RE: Sancrox Quarry Expansion Project (SSD-7293) – Further Information

Attachment 1: Detailed BCD Comments – RE: Sancrox Quarry Expansion Project (SSD-7293) – Further Information

**Connectivity Value - Post Development Site**  
**Connecting Links**  
**(Current linkage widths)**

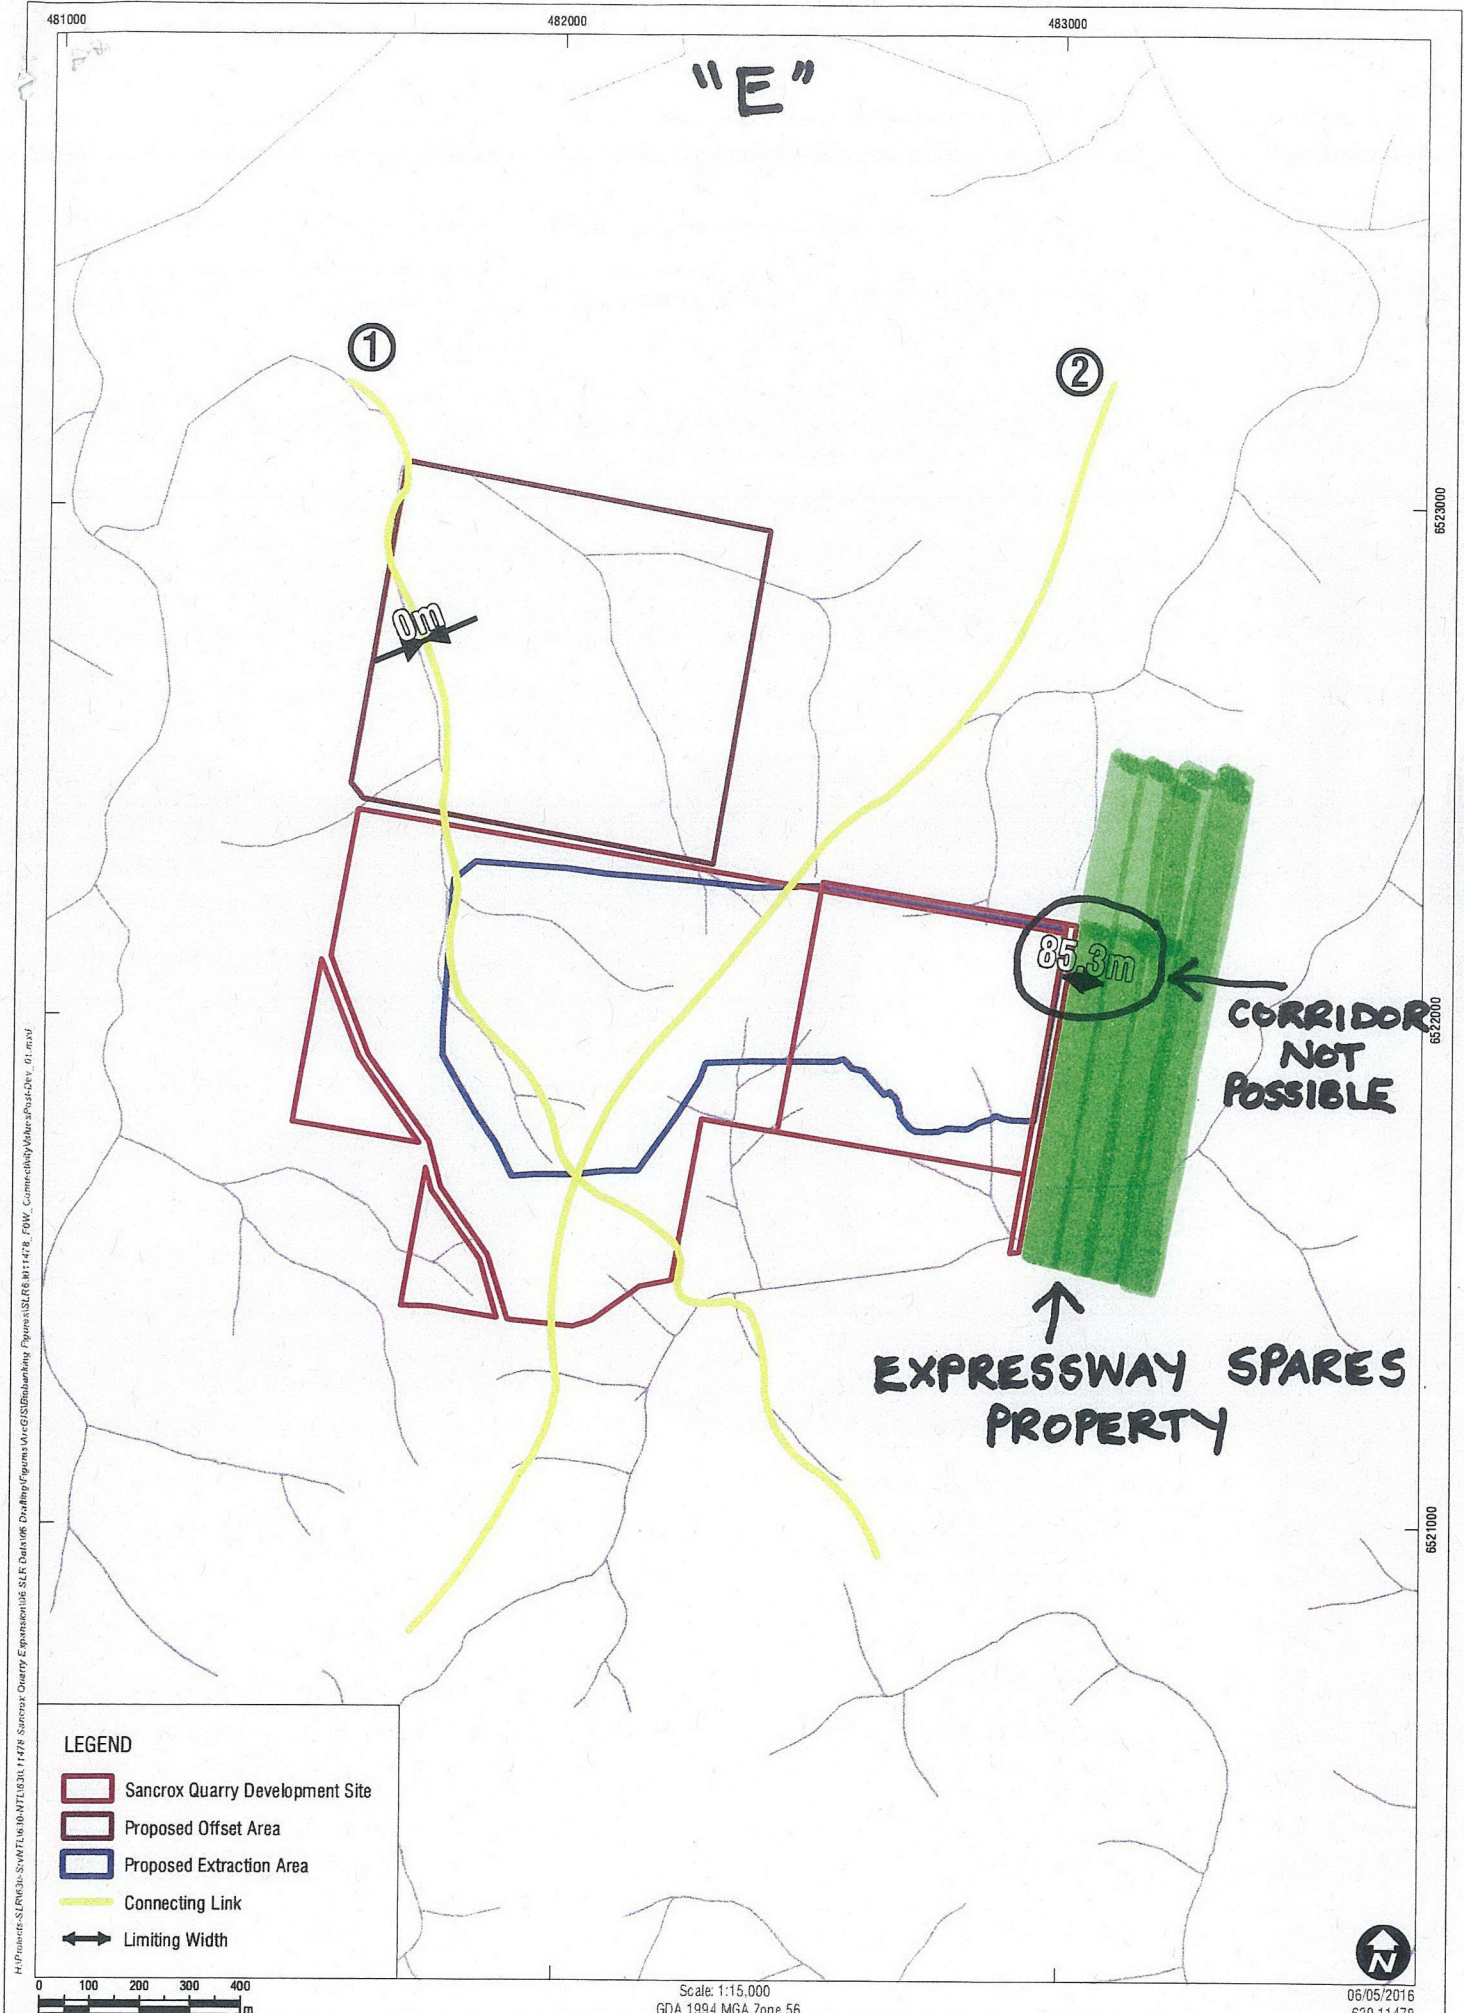
- The connectivity value of the calculator should be justified in relation to the low width value (being 0-5m before and after development), and the mid storey/ground cover condition not being in benchmark condition.
- The assessment of geographic/habitat features appears to have taken a narrow view of the possible threatened species on site. If the habitat feature is present or possible on site, then the threatened species associated with that feature must be included in the assessment. For example, the habitat feature of the Milky Silkpod (*Parsonsia dorrigoensis*) includes areas of open eucalypt forest and the species should be included as this habitat feature occurs in the quarry impact area. All threatened species at this step of the calculator should be reviewed and updated.

3. The FBA calculator should be reviewed, and further justification of the results should be discussed within the BAR.
